Application No: FG/16/25/A
Site Address: Old School House 27 Ferring Street Ferring BN12 5HL
Description of works: Installation of 1 No. internally illuminated sign. (Retrospective).

Thank you for your internet representation made on 27th February 2025 which has been recorded as an objection with the comments as follows:

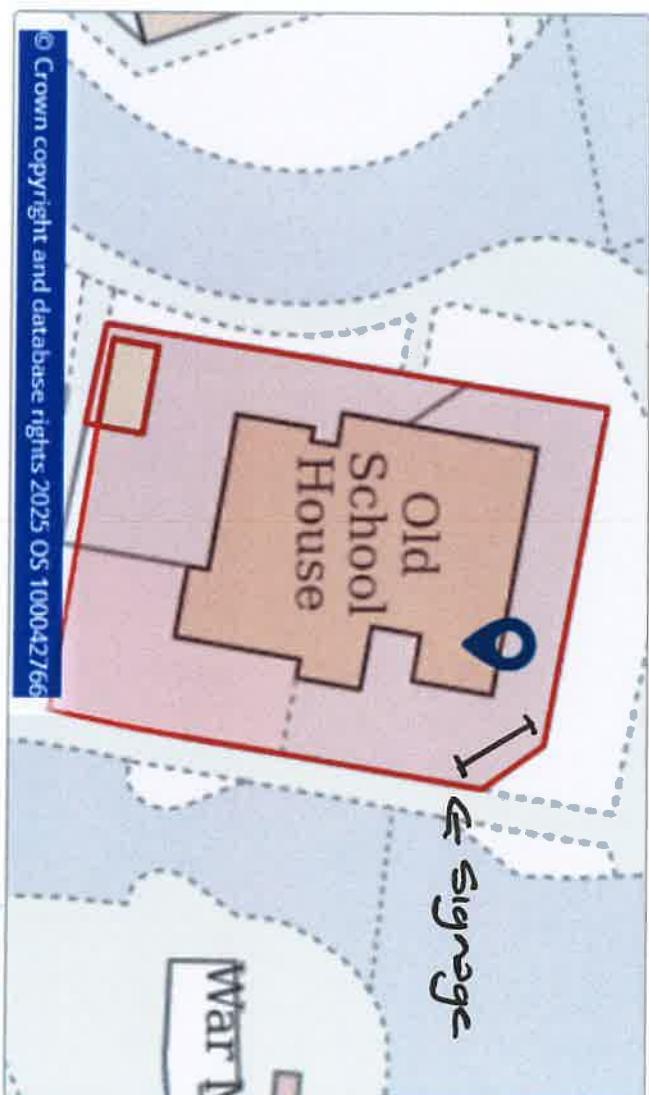
While this retrospective application is for the internal illumination of the signage, the overall impact of the sign and its location is pertinent.

The sign is located opposite the war memorial and at the entrance to the conservation area. Its size, height and colour are an unnecessarily commercially dominant feature unsuited to that position. The internal LED lighting is overly bright, serves no practical purpose and totally unnecessary as it is positioned close to a street lamp.
